From: Rod Brown [REDACTED]
Sent: 10 September 2015 16:05
To: Ross Leal
Subject: Re: R/172/15/PL - Rustington Sports and Social Club

From: Ross Leal
Sent: 10 September 2015 15:24
To: [REDACTED]
Subject: R/172/15/PL - Rustington Sports and Social Club
Attachments: 201509101521.pdf; 201509101521.pdf
Importance: High

Rustington Sports & Social Club, Jubilee Avenue, Rustington:
Proposed Extension to Recreation Bar with ramped access and externally accessible storage

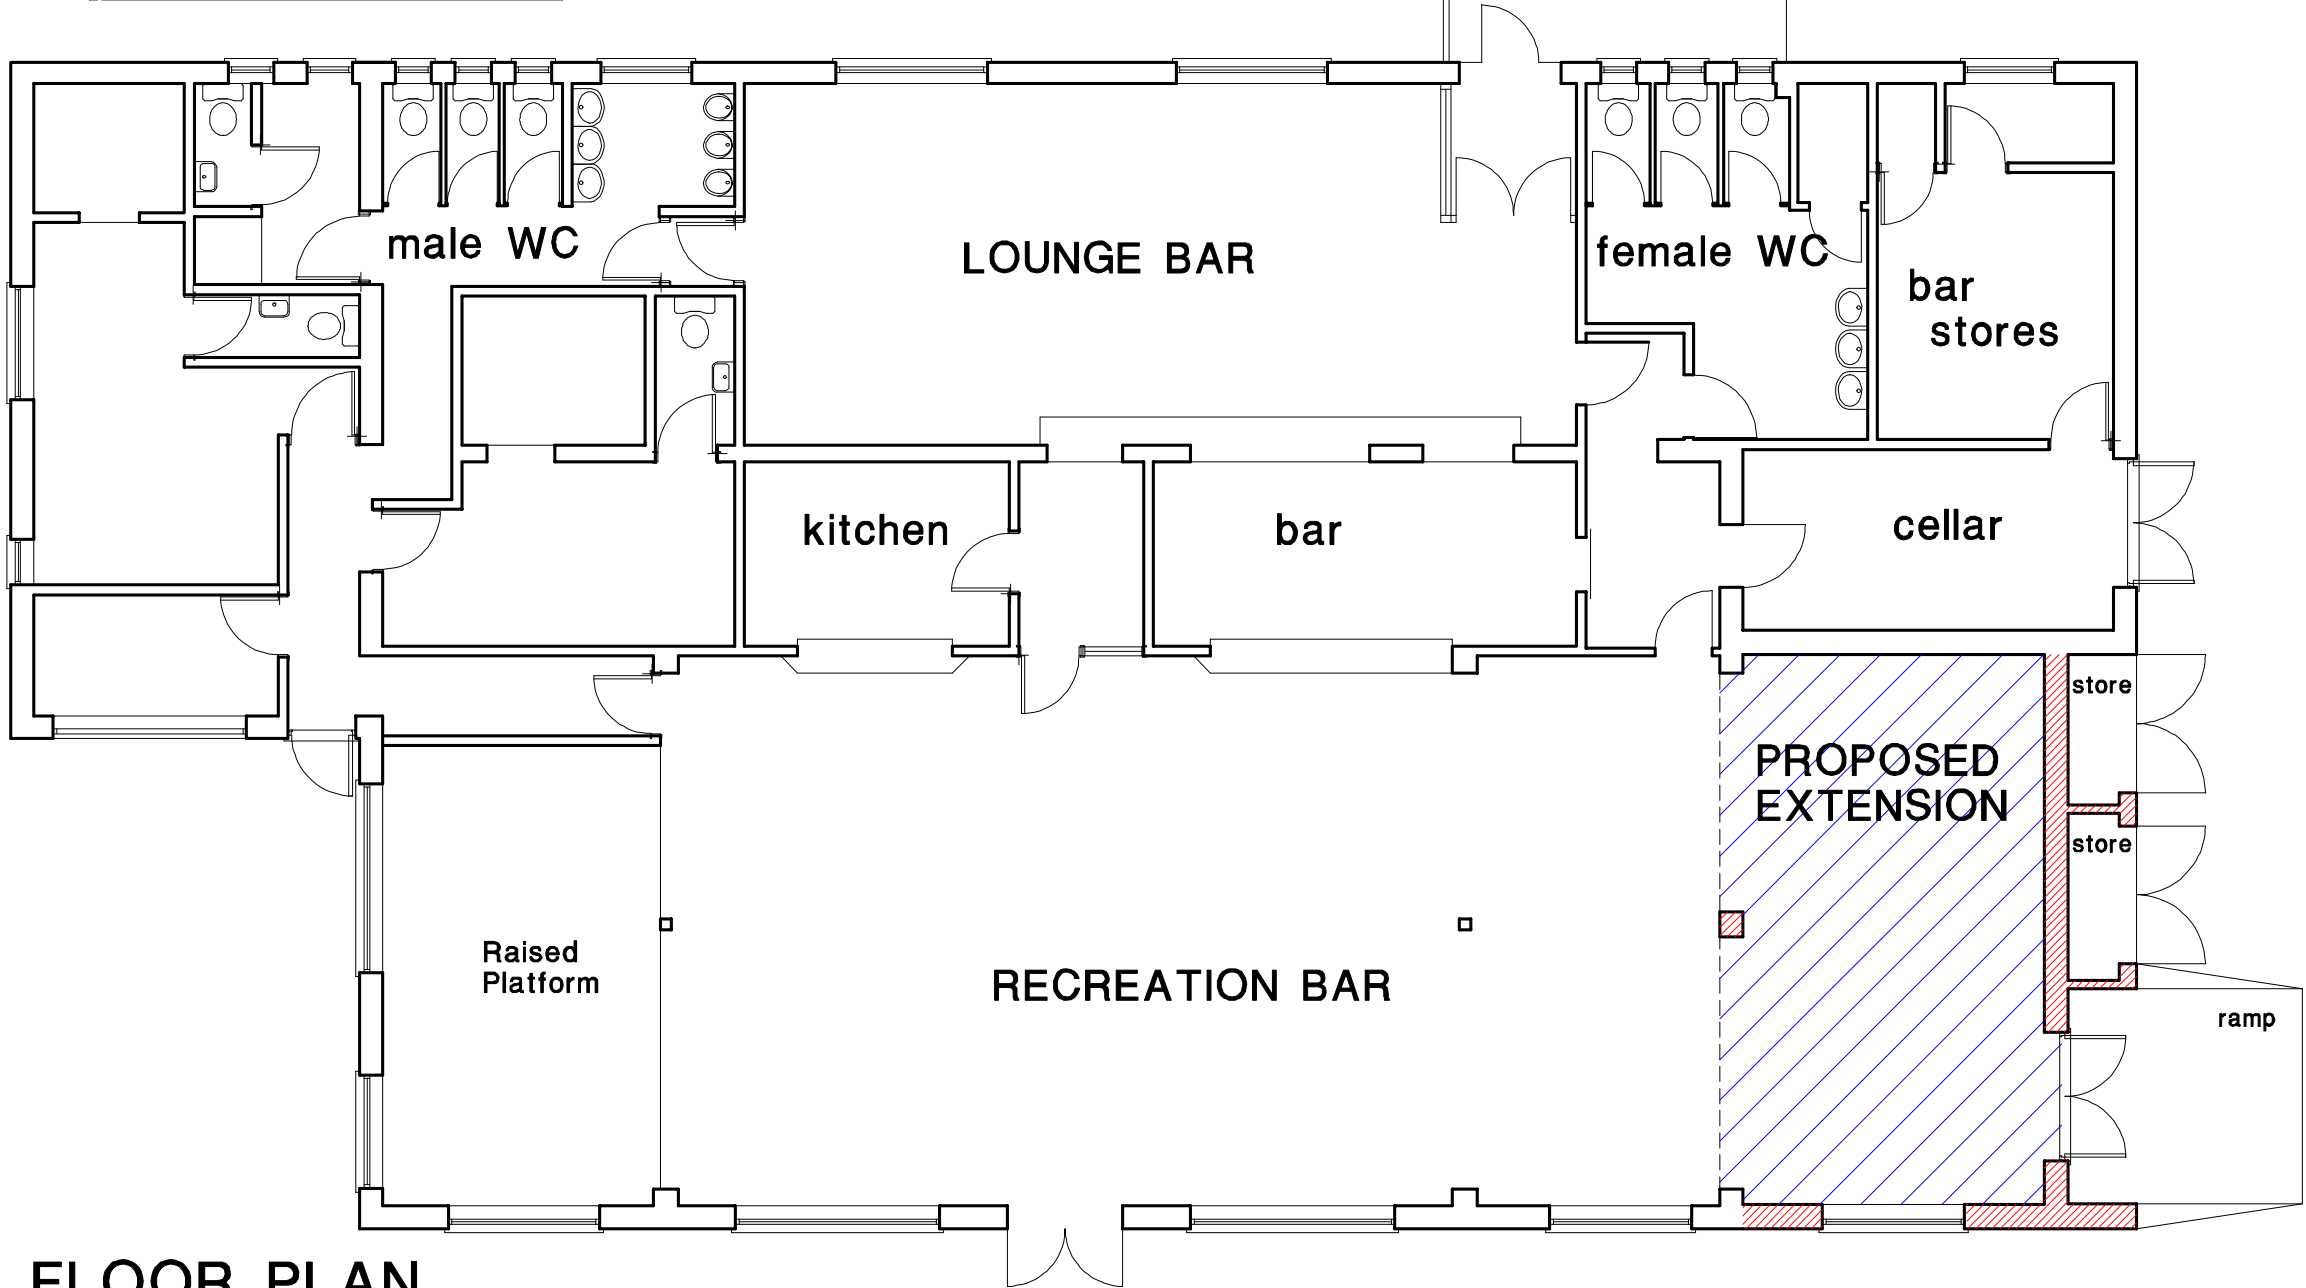
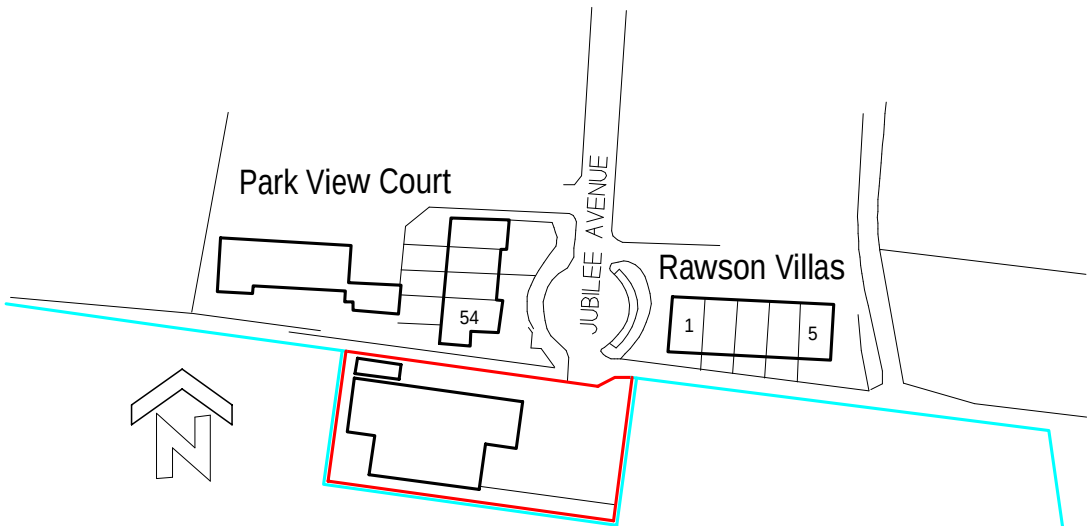
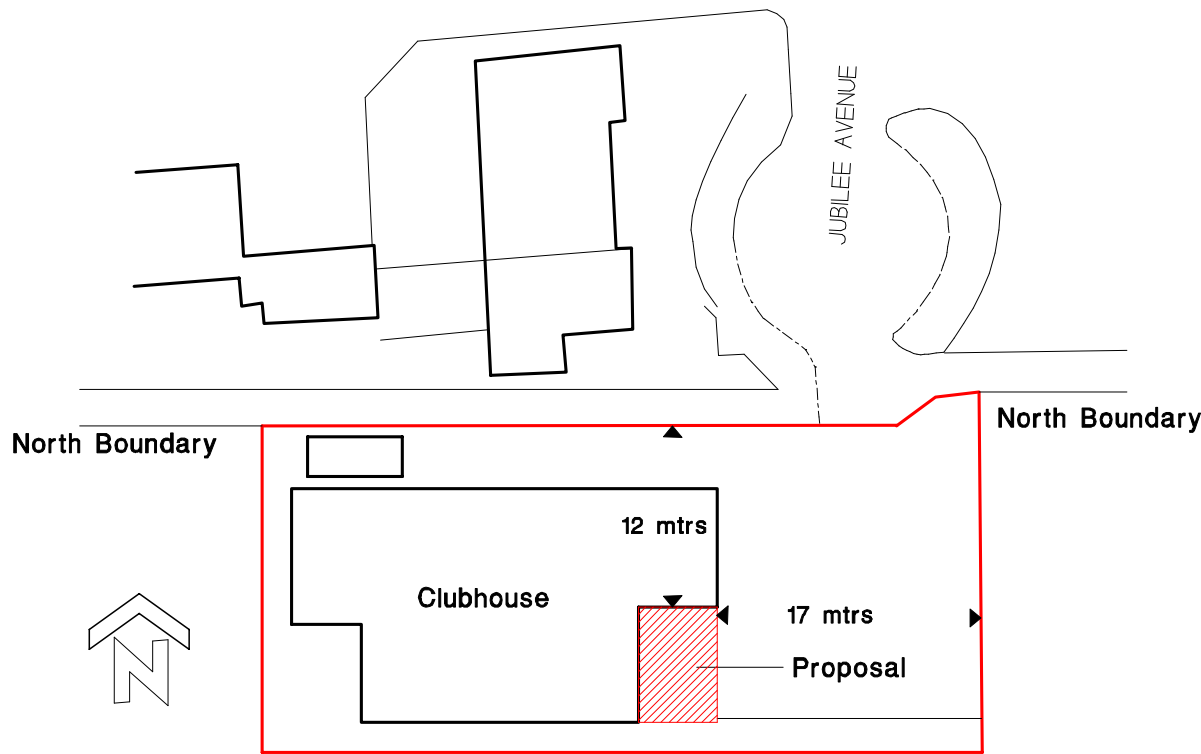
As discussed, There is a shortfall in parking provision at this site for the floor area of the Club as existing. The proposed development makes no provision for car parking to serve the new floor area and as such, the proposal will result in increased demand for parking that cannot be met on site. Additional on-street parking will therefore result. This will be detrimental to highway safety and to residential amenity (noise).

The parking standard for a public house has been applied, as was previously the case for the refused application R/82/93. This is now 1 space per 5sqm of public area and 2 spaces per bar or 5m length of bar. The requirement under this standard would be 29 spaces + 2 spaces for the bar = 31 spaces.

There is therefore an existing shortfall in provision at the site for the existing floor area of between 16 and 19 car spaces.

The proposed public floor area is 29.4sqm. This gives rise to a requirement for an additional 6 spaces and an increased shortfall in parking provision of 22 to 25 spaces.

In the light of the above, it is clear that existing and proposed parking provision at the site is inadequate. The proposed extension would therefore give rise to increased parking demand that cannot be met on site and would therefore give rise to increased on-street parking and the resulting potential for obstruction to the free flow of traffic and danger to highway users, including pedestrians and cyclists.

As discussed, it is my view that the proposal must at least 'wash it's face' in terms of parking provision and **must therefore provide at least an additional 6 parking spaces**. During my site visit, I noted that freely usable spaces were between 12 to 15 spaces.

'The hard surfaced area to the east of the clubhouse is formally laid out for parking with 12 fully accessible spaces. There are 3 more potential spaces which could be utilised, but doing so could cause some blocking of car paces. Of these, 2 are in the area where the extension is proposed and one is in the south east corner of the parking area. There are therefore between 12 to 15 spaces to serve the existing clubhouse.'
